9th August 2021

Relationship between the NWL and the A47 scheme A47 North Tuddenham to Easton Examination.

Appendix B: Wood Lane Junction showing connection to Norwich Western Link (in pink)

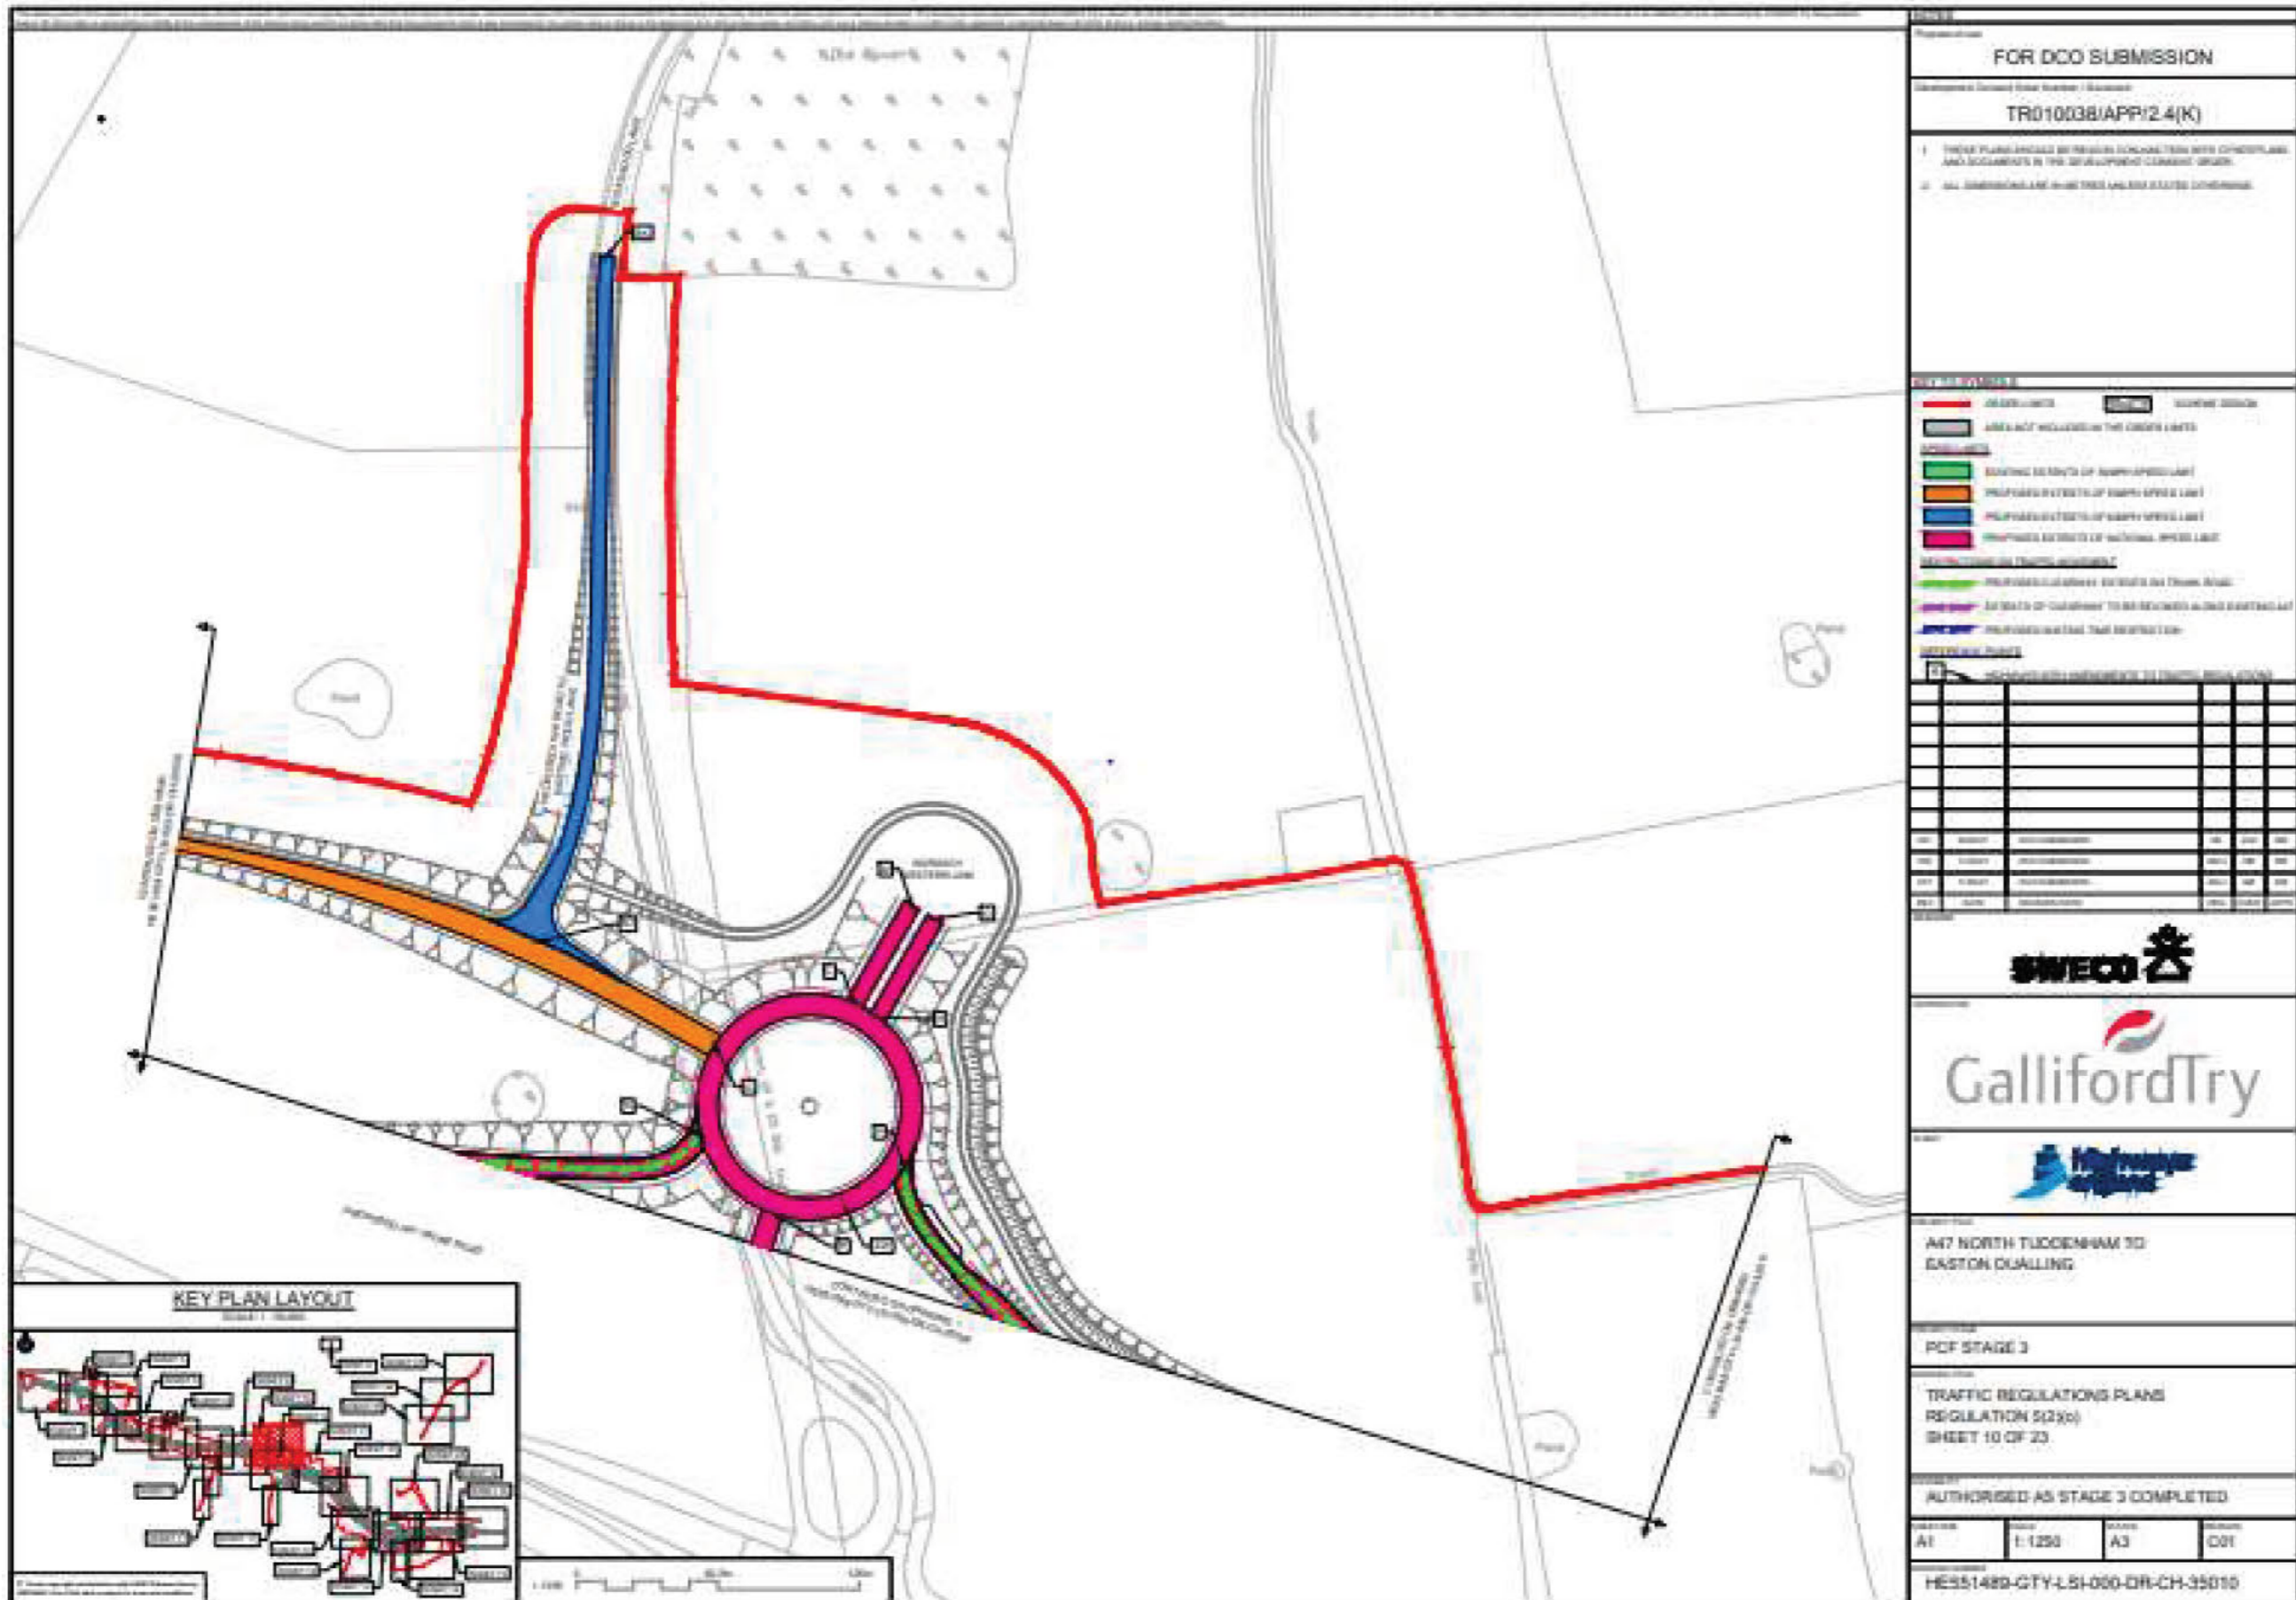
I also note the Norfolk County Council (NCC) in its representation is lobbying for the Wood Lane underpass from its proposed NWL should be dual carriageway and considers that the NWL should be raised as part of the Inquiry.
